DRB CASE ACTION LOG - BLUE SHEET

Project #: 1009240 Application #: 12-70175

Project Name: Emil Mann Addn

10. **Project# 1009240**  
12DRB-70125 MINOR - PRELIMINARY/ FINAL PLAT APPROVAL  
JACKS HIGH COUNTRY INC agent(s) for SABRINA ALMAGER request(s) the above action(s) for all or a portion of Lot(s) PORTION OF LOTS 1-3, **EMIL MANN ADDITION** zoned C-1, located on ZUNI RD SE BETWEEN ALCAZAR SE AND CHAMA SE containing approximately .4977 acre(s). (L-19) **THE PRELIMINARY/ FINAL PLAT WAS APROVED WITH FINAL SIGN-OFF DELEGATED TO TRANSPORTATION FOR INTERSECTION RIGHT-OF-WAY RESOLUTION.**

PLAT OF  
**LOT 3-A, BLOCK 2**  
**EMIL MANN SUBDIVISION**

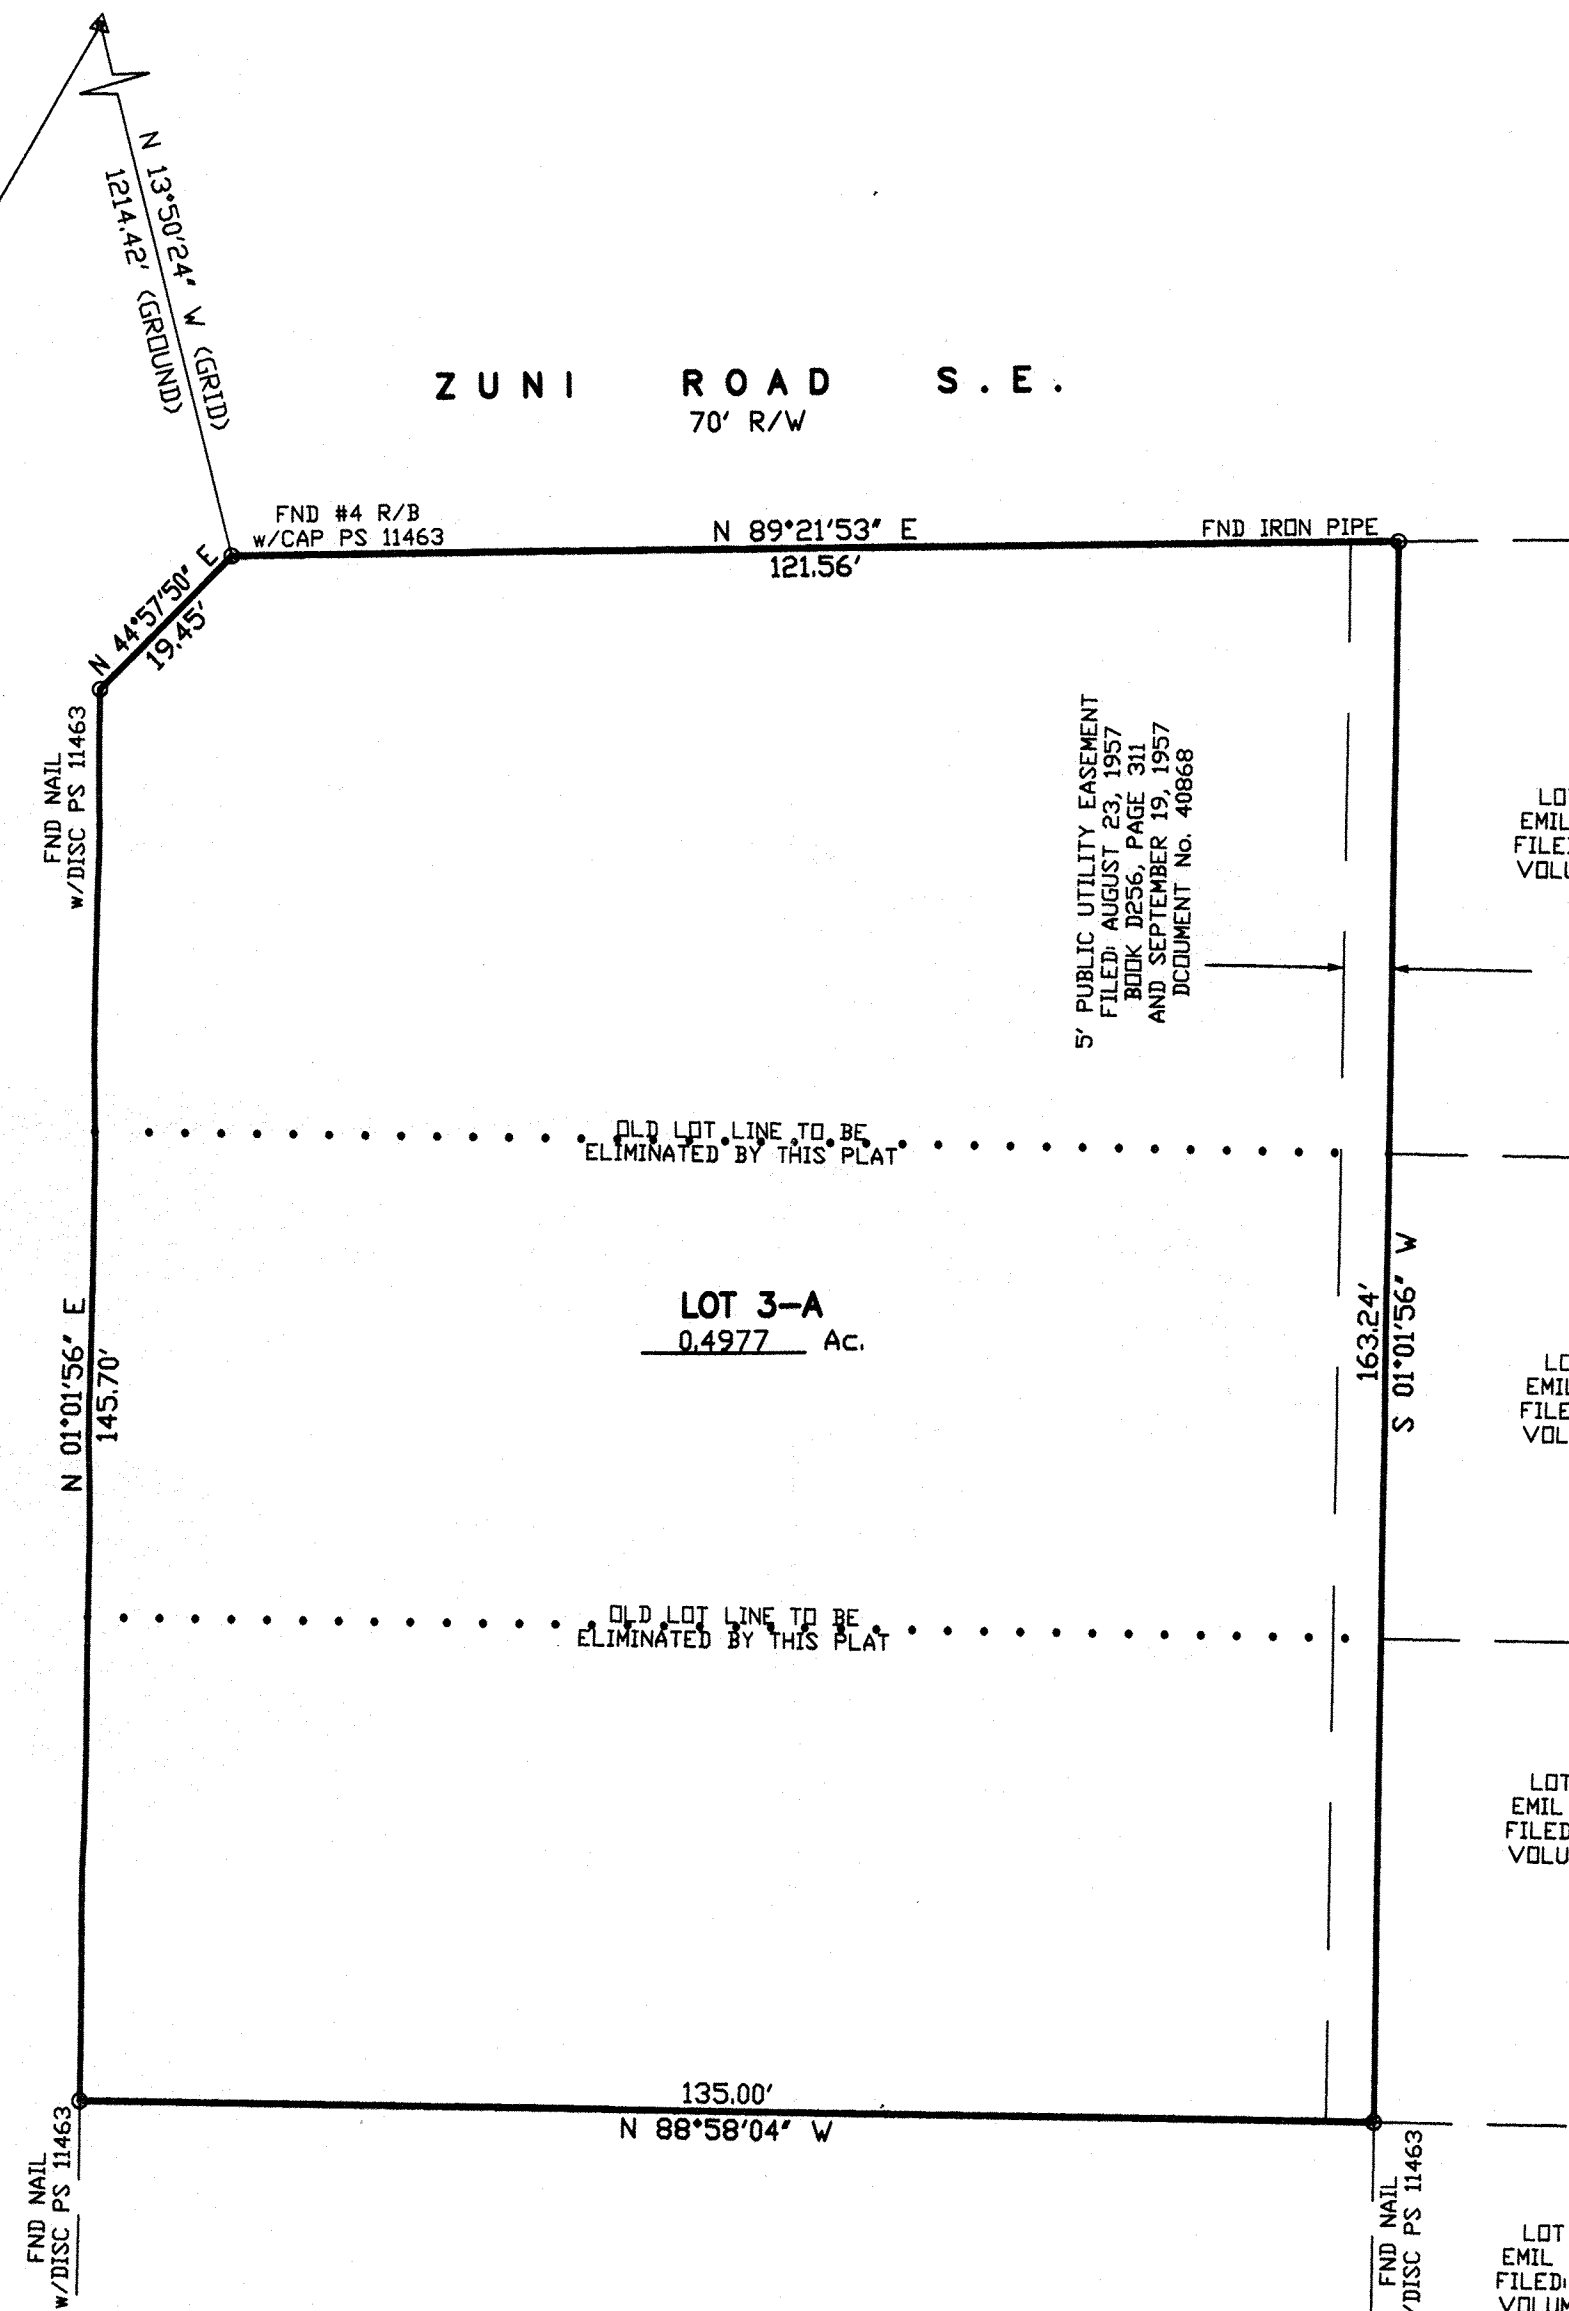
TRANSPORTATION: resolve intersection R-OW
